ADC PARKS & GREENSPACE ARBORICULTURE CONSULTATION

PLANNING APPLICATION: A/128/12/T

ADDRESS: Pinehurst West Drive Angmering BN16 4NL

BRIEF DESCRIPTION: 1x Sycamore Tree - Remove horizontal branch on north west side, 3.5 metres from ground, to lift crown and balance tree. Crown reduction - Remove any dead wood found.remove up to 1.5 metres mainly on northern side of tree again to balance shape

Sketch as per previous application.

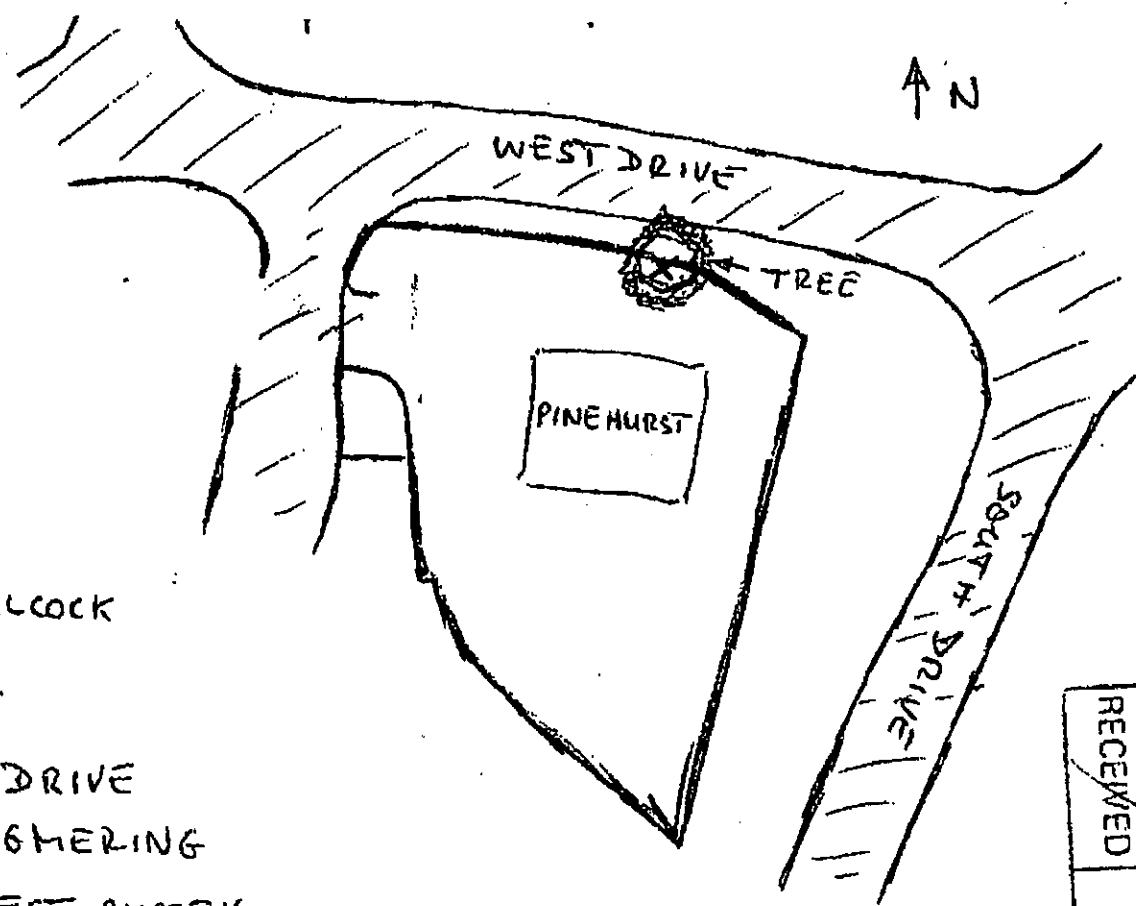
The Sycamore has produce fine re-growth which if carefully reduced could provide a framework towards a balanced and symmetric crown shape. The tree does not require a re-lop, cutting hard into the branchless stems as this would stimulate the growth of 'water-shoots' once again and reiterate the problems which are being experience at this present time. A younger Sycamore has been pruned appallingly further along this stretch of raise ground towards the west leaving jagged cuts.

The crown lift proposed at 3.5m is acceptable. A crown reduction to not exceed 1.5m is acceptable. Both operations have been written into a Planning Condition and must be abided by, as follows;

- The Crown Reduction should only affect those parts which protrude beyond a natural outline.
- The Crown Reduction must not exceed branch lengths of **1.5m**
- All pruning cuts must leave healthy multiple leaf/bud bearing side branches which are **1/3rd** or greater in diameter of the removed branch.
- Pruning cuts must be flat and smooth, kept as small as possible and cut at an optimum angle leaving the branch collar intact.
- Pruning wounds of all removed live branches should not exceed **40mm** in diameter.

- The crown of the tree will be pruned to provide a maximum vertical clearance above ground level over the garden by **3.5m**.

- Branches found within this clearance height having diameters greater than **50mm** should be shortened and no more than **15%** of the leaf bearing growth of that branch should be removed.
